Re: Request for Council's Advice on SEARS

Liverpool City Council was invited to provide comments on the Planning Secretary's Environmental Assessment Requirements (SEARS) for the proposed development of an automated distribution facility at Lots 4-5, 6-7 and 8 Buchan Avenue, Edmondson Park.

Attachment A – Detailed comments and required information

02 SHADOW DIAGRAM 09H00 - 21 JUNE
SCALE: 1:2000@A1

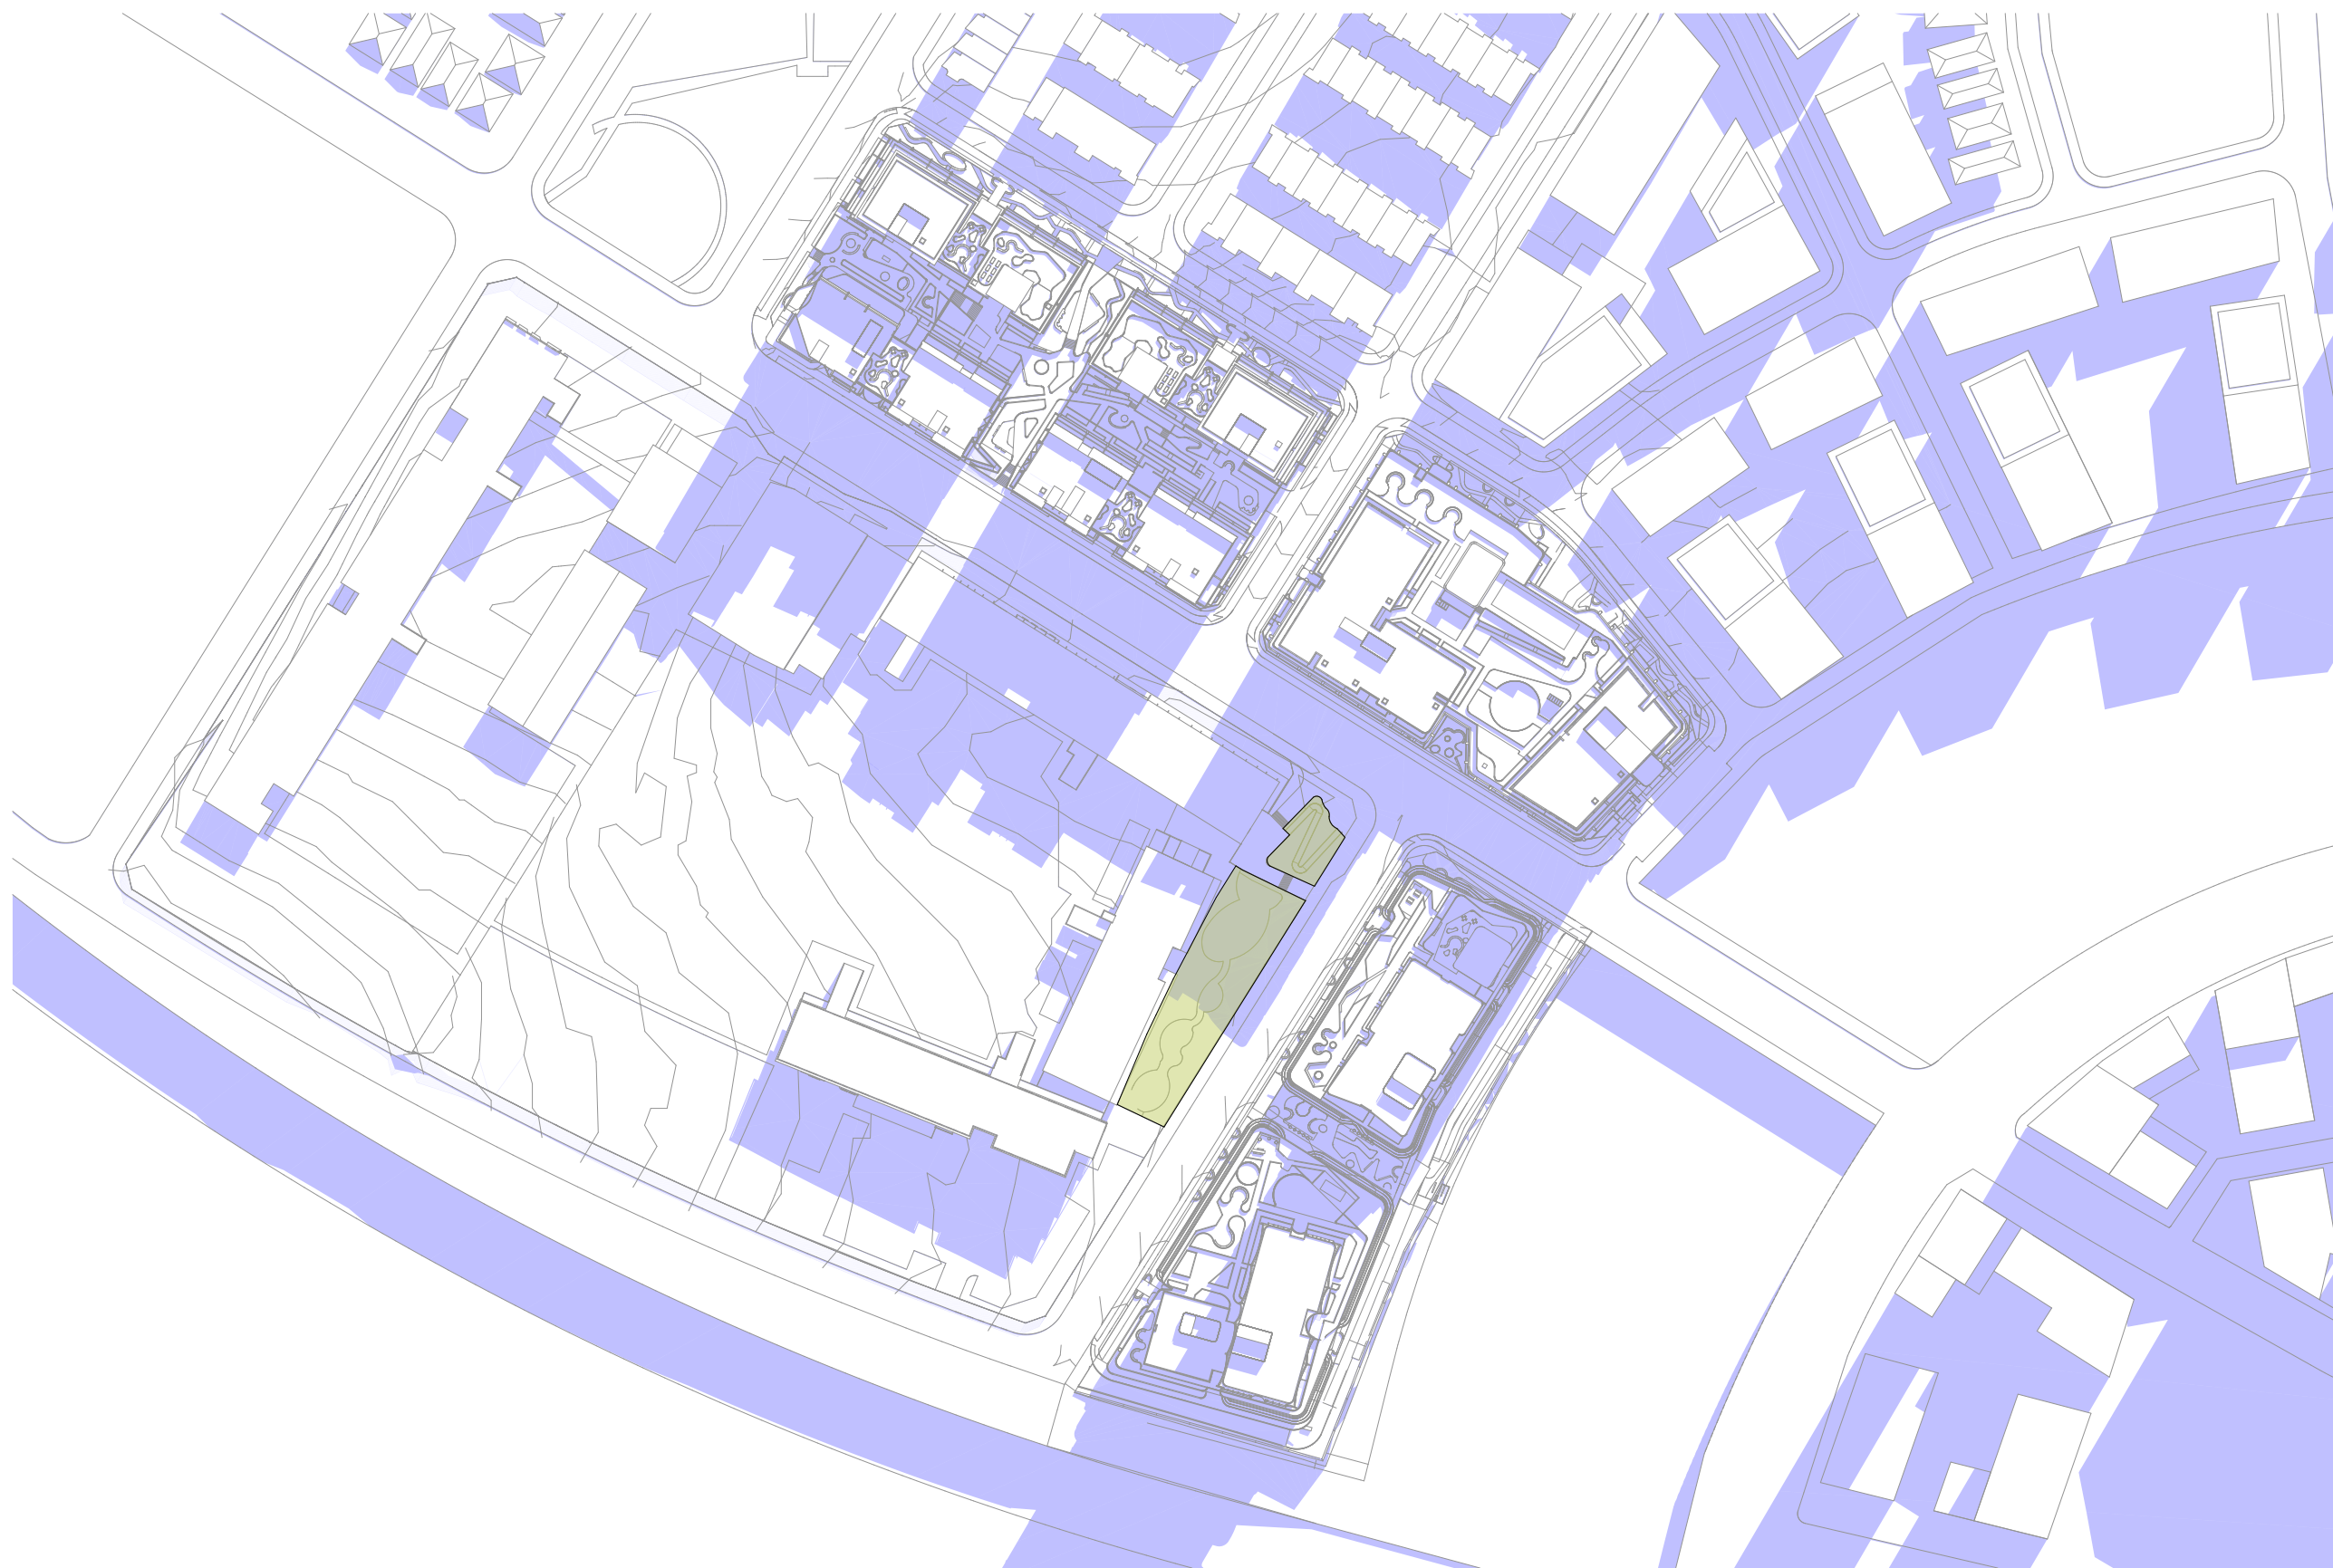
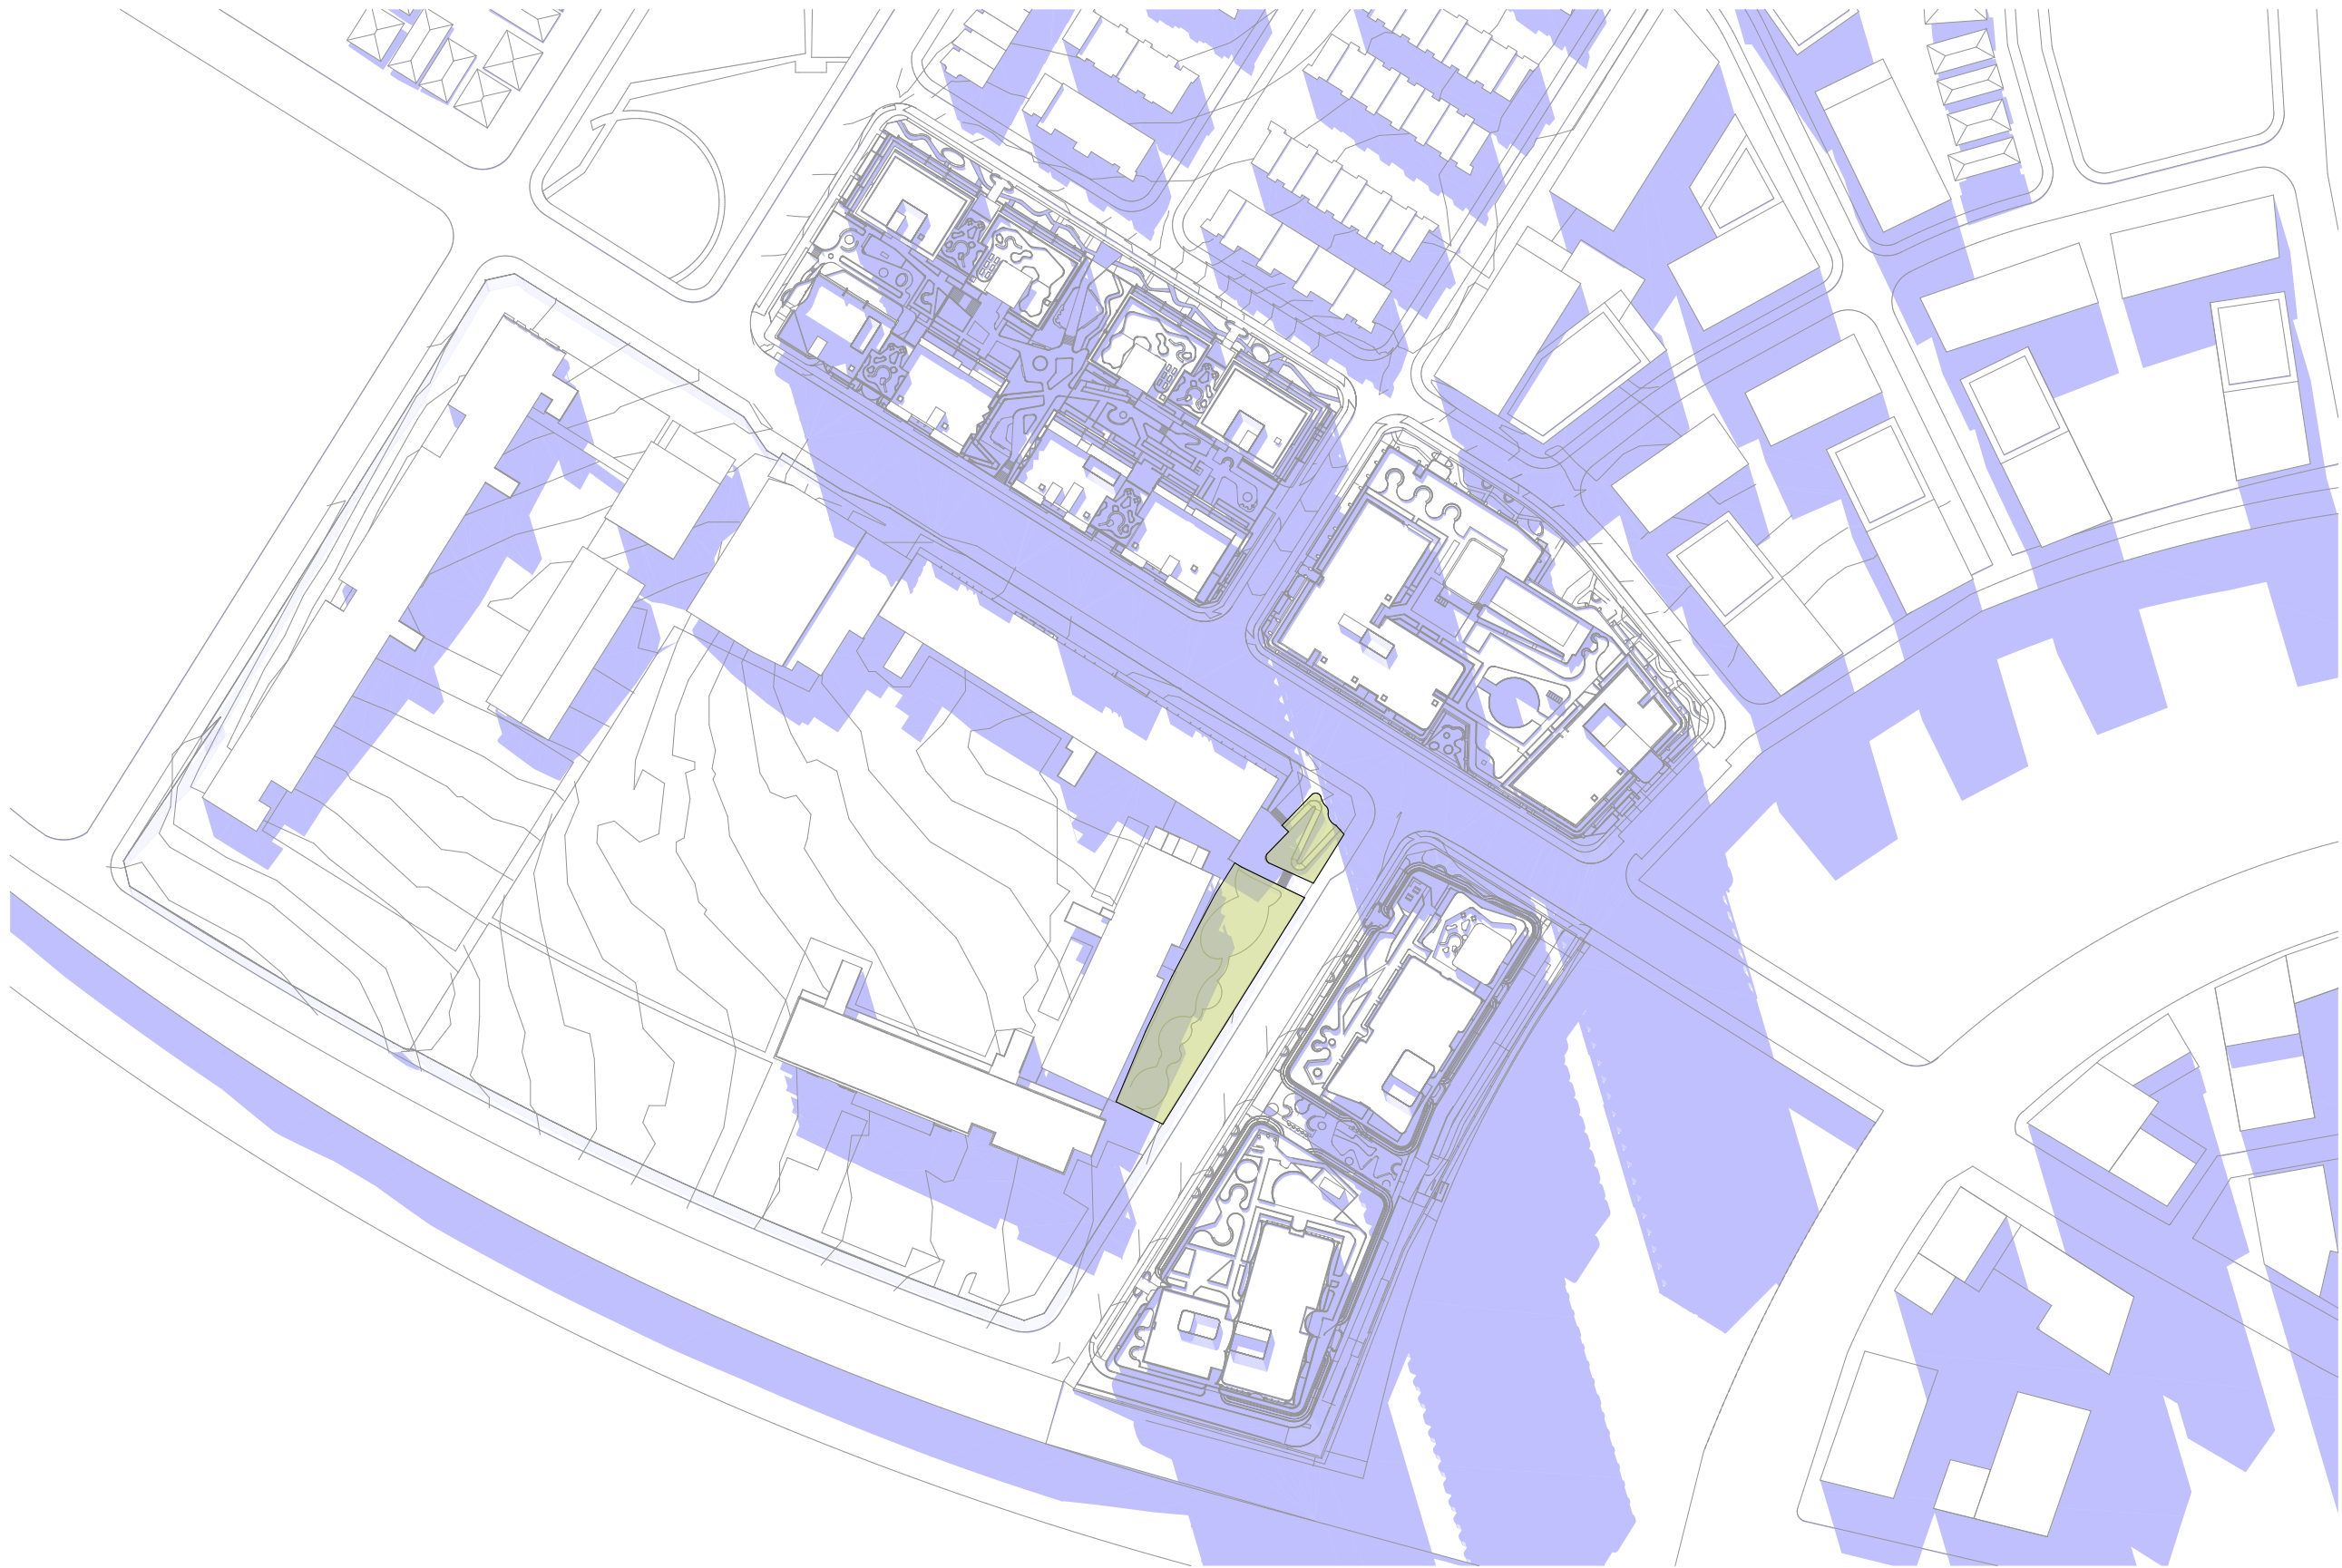
Strategic Planning are concerned about the bulk and scale facilitated by this concurrent rezoning and SSD. Overshadowing, and Overlooking analysis is required.

- Economic Impact Assessment including demand analysis for additional B4 Zoning in the area, and any additional retail land use (supermarket, gyms etc).
- Urban Design Report which includes analysis of bulk and scale, overshadowing of existing low scale residential dwelling, surrounding open space and schools.
- Infrastructure Demand Analysis
- Open Space Needs Analysis (including the additional needs as a result of additional density)
- Community Facilities (including the additional needs as a result of additional density)
- Social Impact Assessment
- Traffic Impact Assessment
-
